KIRKLEES METROPOLITAN COUNCIL INVESTMENT & REGENERATION SERVICE

DELEGATED DECISION TO DETERMINE APPLICATIONS FOR LISTED BUILDING CONSENT

Reference No:	2025/44/92476/W
Site Address:	Queensgate Market, Princess Alexandra Walk, Huddersfield, HD1 2UJ
Description:	Discharge of details reserved by conditions 14 (blinds), 15 (flooring), 17 (market stalls), 19 (partition wall/glazed screen) on previous permission 2024/90270 for Listed Building Consent for demolition, alteration, refurbishment and extension to create library, food hall and public realm (part within a Conservation Area)
Recommending Officer:	Katie Chew

Application: 2025/92476

DRAWING TITLE
GA ELEVATIONS
North & East Elevations

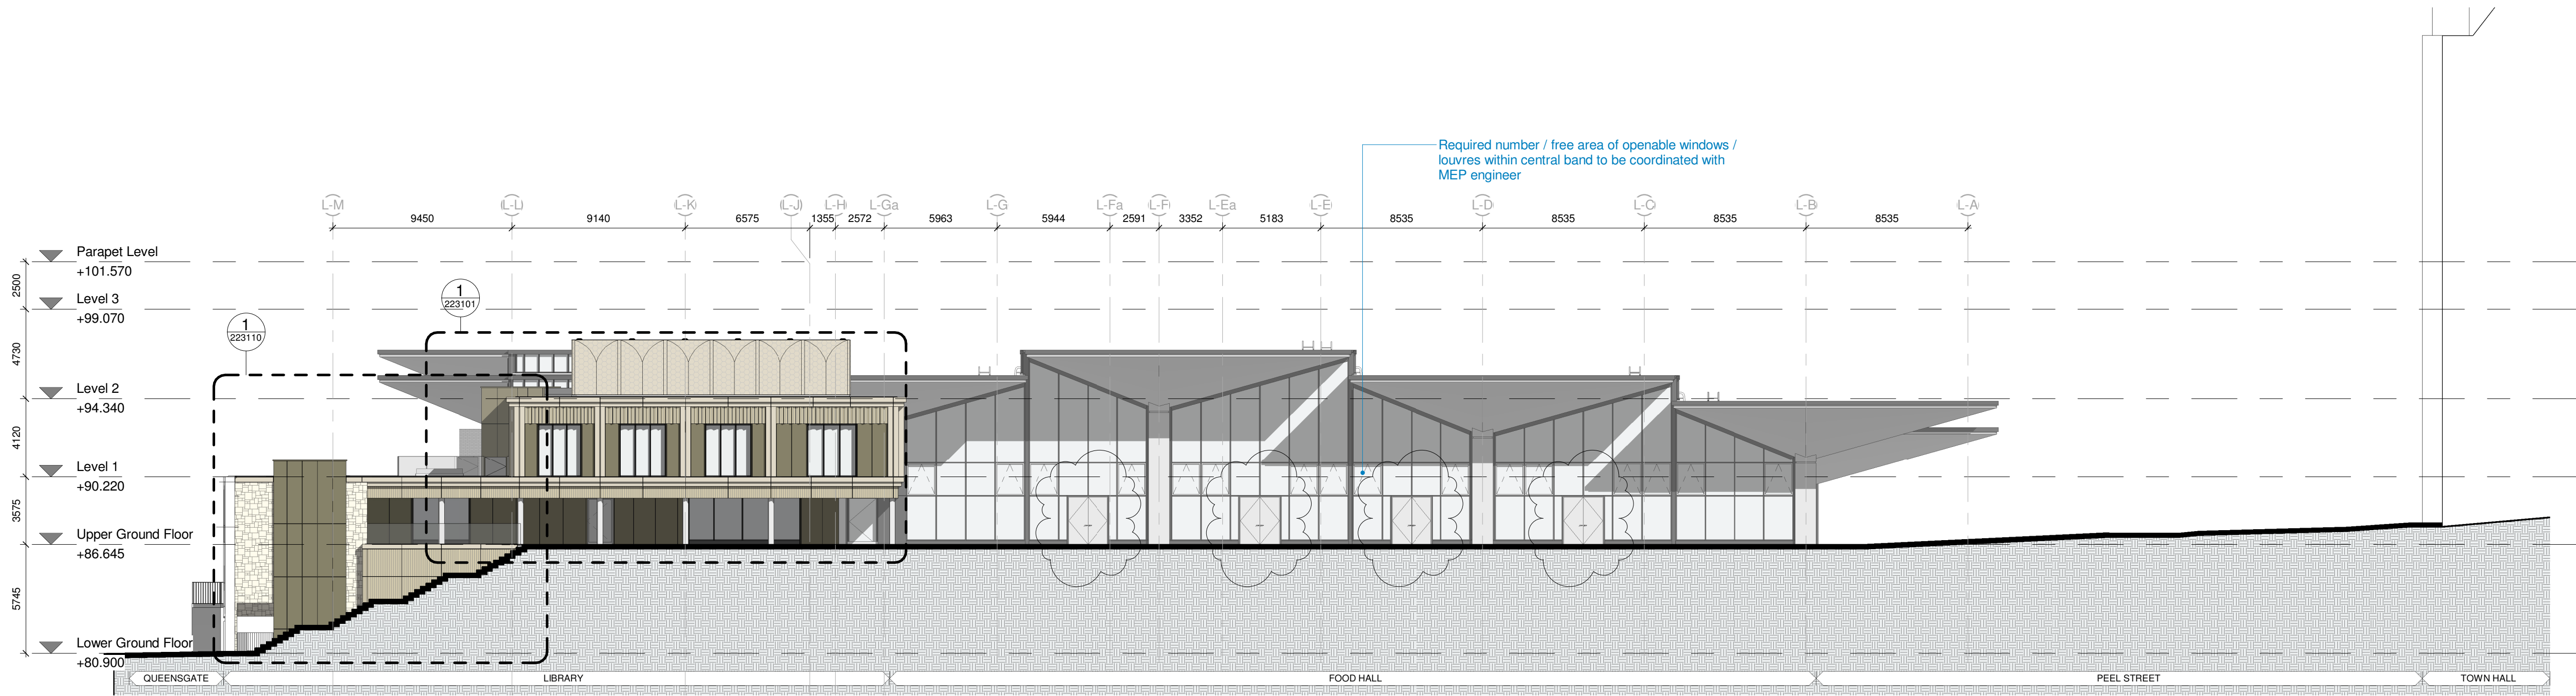
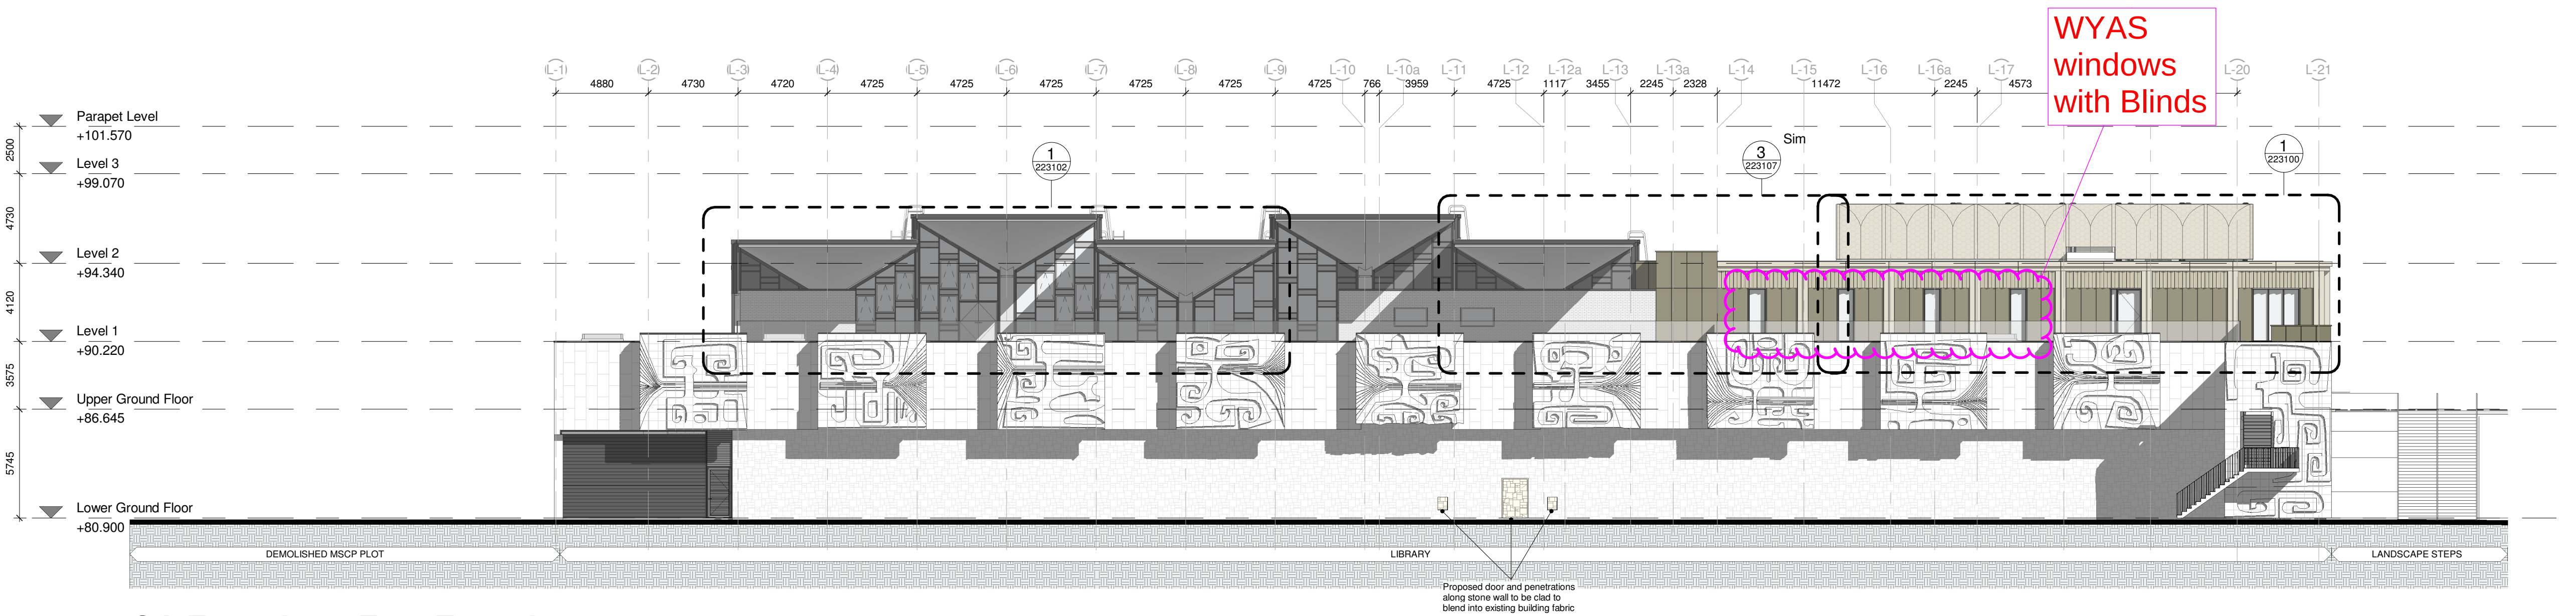
14. The blind is installed for glare for the WYAS research room and library to permit no UV to pass through. The proposed colour, finish and fixings are considered acceptable.

Officers concur with the conclusions made by KC Conservation & Design and therefore recommend that Condition 14 is approved. However, Condition 14 has the following ongoing requirement, which must be adhered to, to ensure the ongoing compliance of the condition:
